14 February 2023

TfNSW Reference: SYD20/1175/07
DPE Reference: SSD-9978934

**RESPONSE TO SUBMISSION
STAGE TWO COCKLE BAY WHARF REDEVELOPMENT (SSD-9978934)
249 WHEAT ROAD, COCKLE BAY**

COCKLE BAY PARK  
 Swept Paths Assessment - CBP Drop-off  
 Wheat Road / Harbour Street

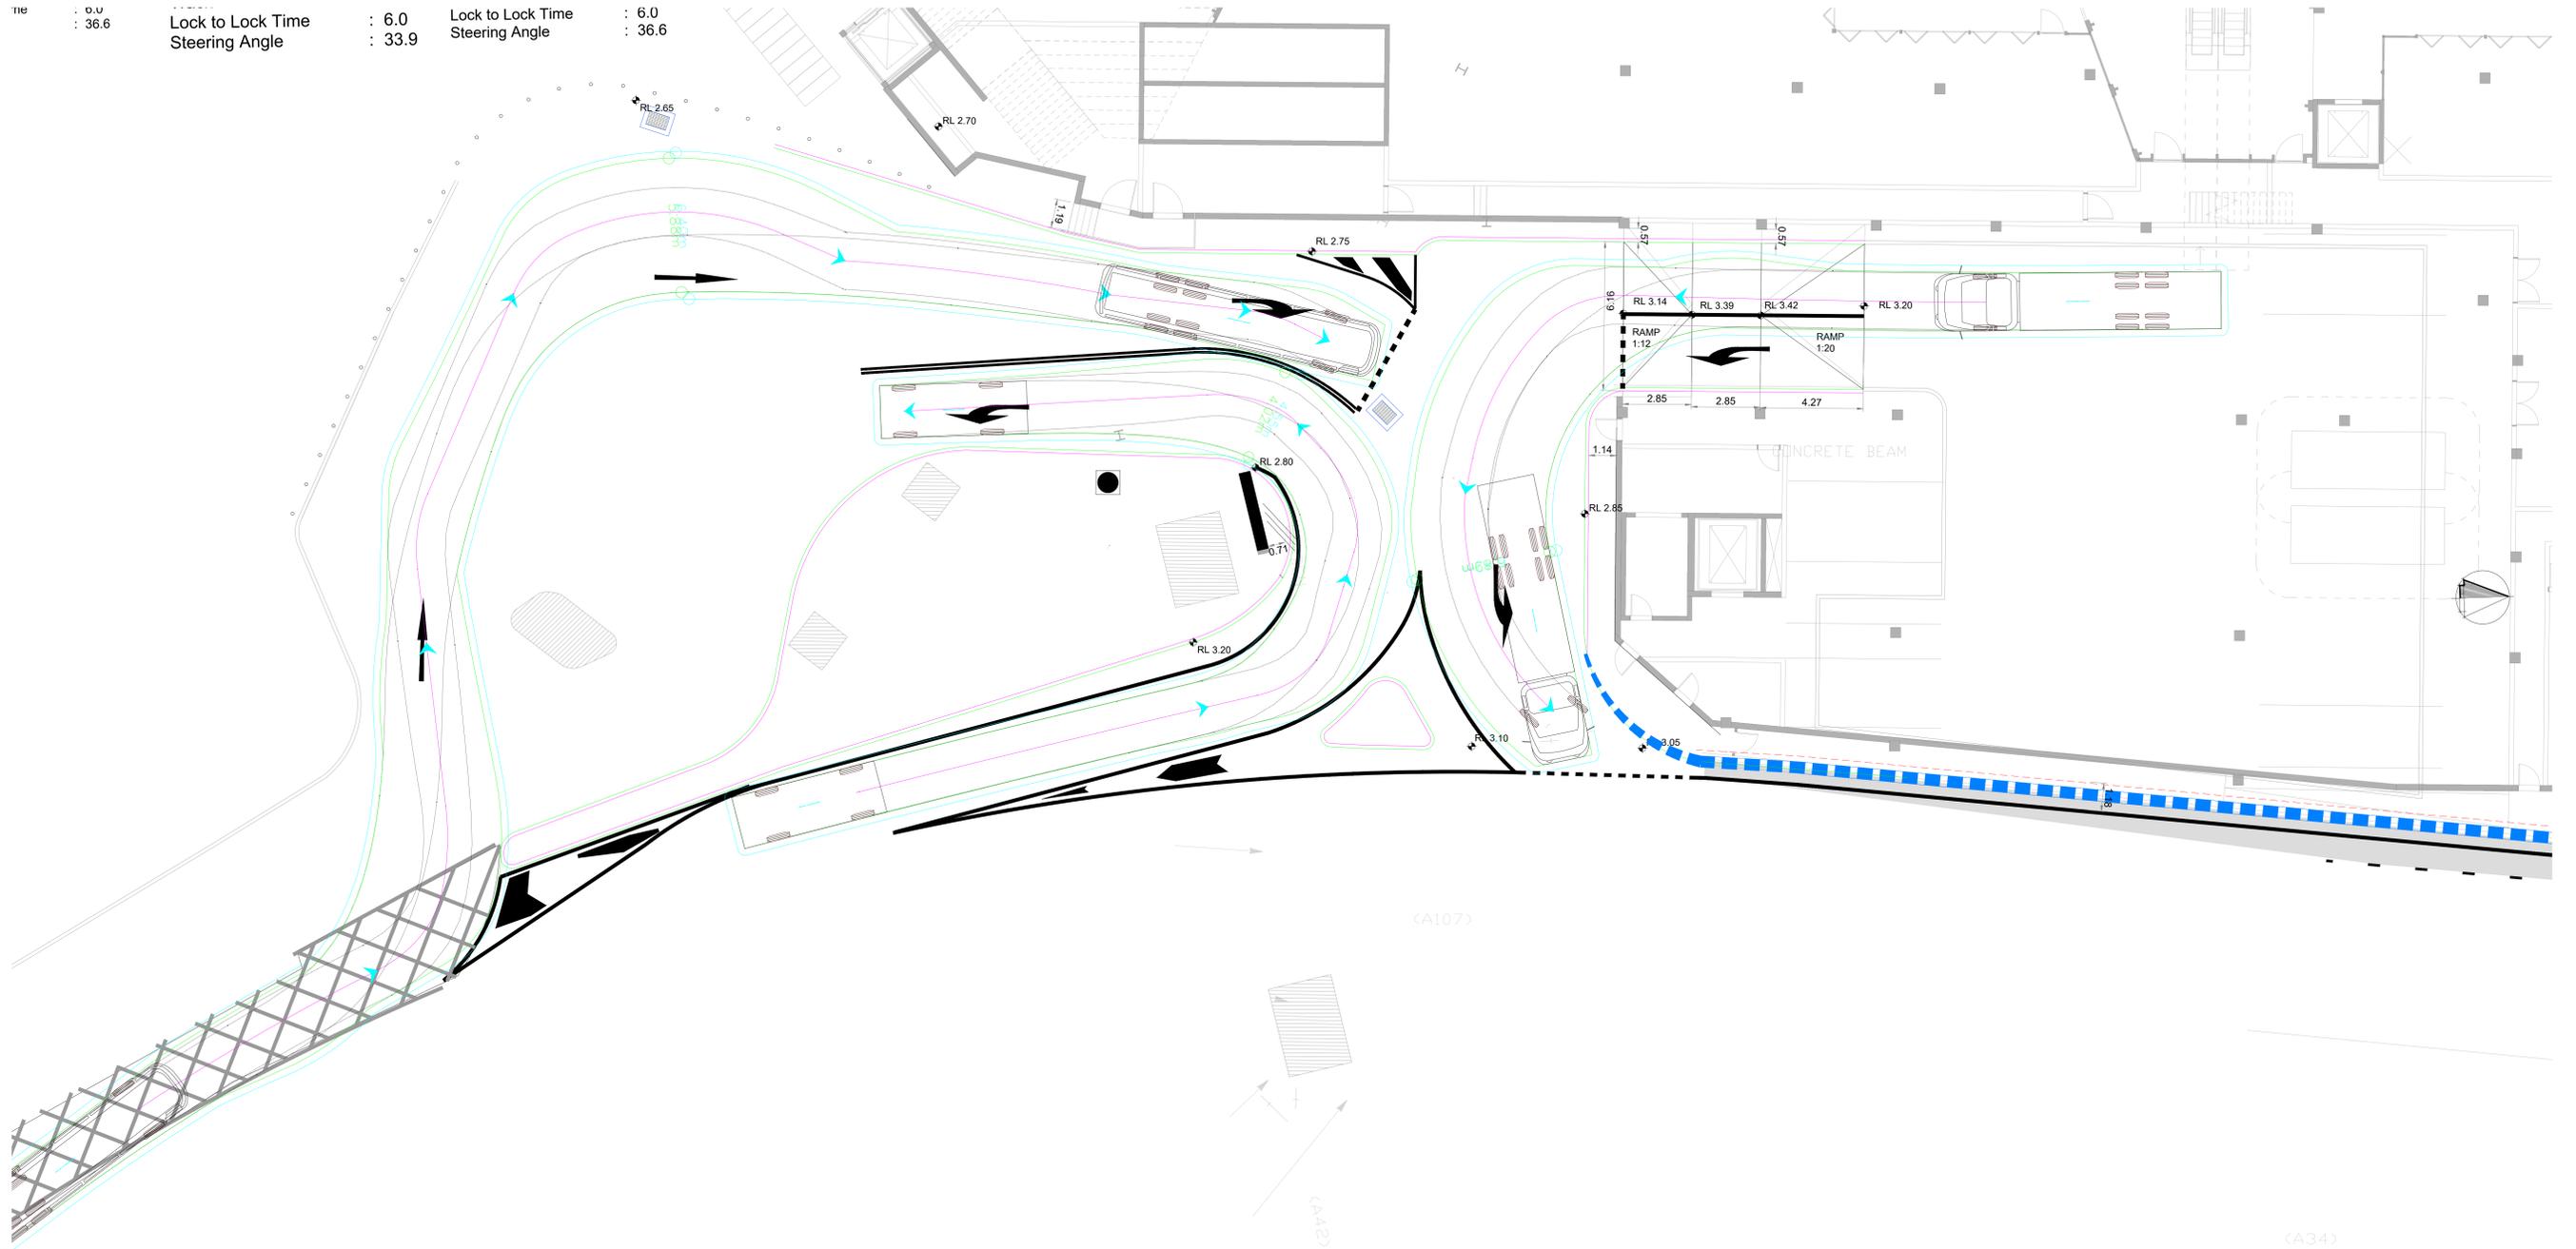
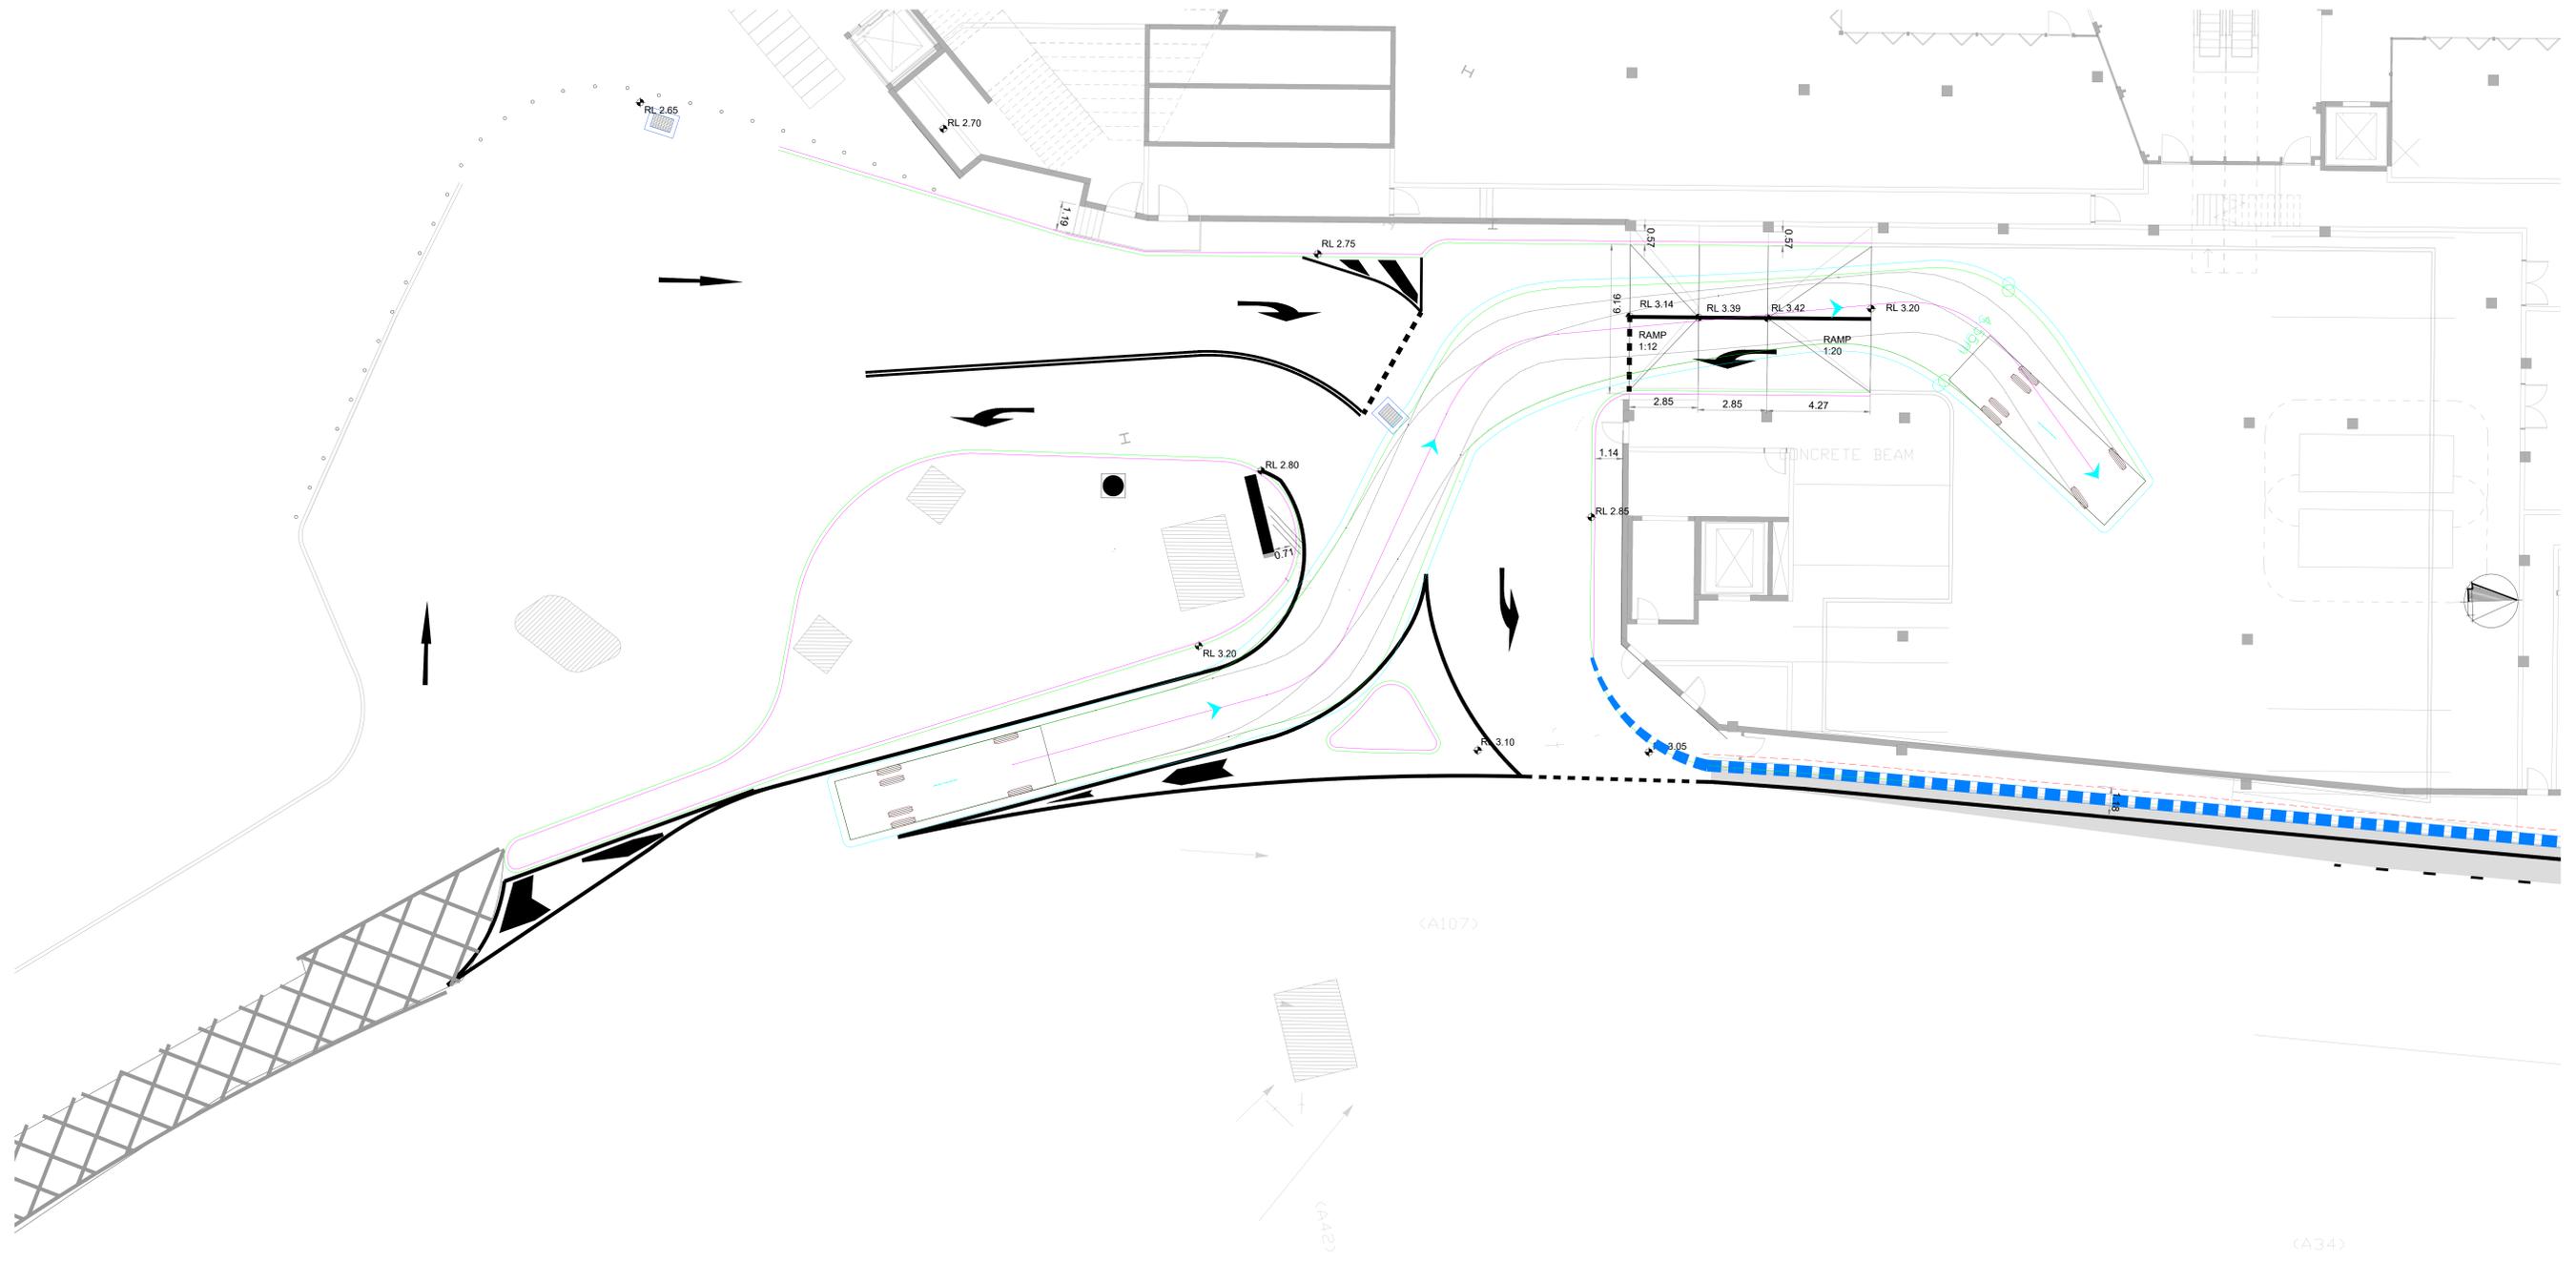
- Sight distance assessment should be based on a formalised Safe Intersection Sight Distance (SISD) checks and demonstrated in the vertical plane as well as horizontal plane. The vertical plane is particularly important due to the proposed F Type barrier.
- Appendix W – Swept Path analysis indicates HRV as the largest vehicle. However, 14.4m buses will be entering and exiting the internal service road. Swept path analysis should be updated showing the 14.4m bus traversing through the internal service driveway and egress driveway on Harbour Street.
- Concern is raised with delays and queuing from vehicles exiting the egress driveway on Harbour Street which may block access to the loading dock. This is a particular concern for:
 - MRV vehicles and Buses due to the swept path constraints at the Harbour Street intersection and access is unrestricted during peak periods.

- An assessment of the forecast demand for the porte-cochere was undertaken for the AM peak only. The demand in the PM will be generated by both the commercial and retail land uses.
- In addition, justification for the development not generating or attracting private buses or coaches has been provided. It is considered likely the retail and public domain land uses will generate some private bus or coach trips.
- Queuing assessment of the porte-cochere has been undertaken however, there could be instances where queue will overflow. This needs to be reviewed to identify measures that would ensure road safety and operational issues do not occur on Wheat Road.

- Swept path analysis should be updated to include 14.4m bus accessing the internal service road and Harbour Street access points. Designs of the internal service road and access driveways should be updated accordingly.

- Location of vehicle stopping/parking area for valet parking vehicles, taxi and pick and drop off facilities.
 - Details of the types and frequency of vehicles accessing the porte-cochere and updated swept path analysis based on the largest vehicles.
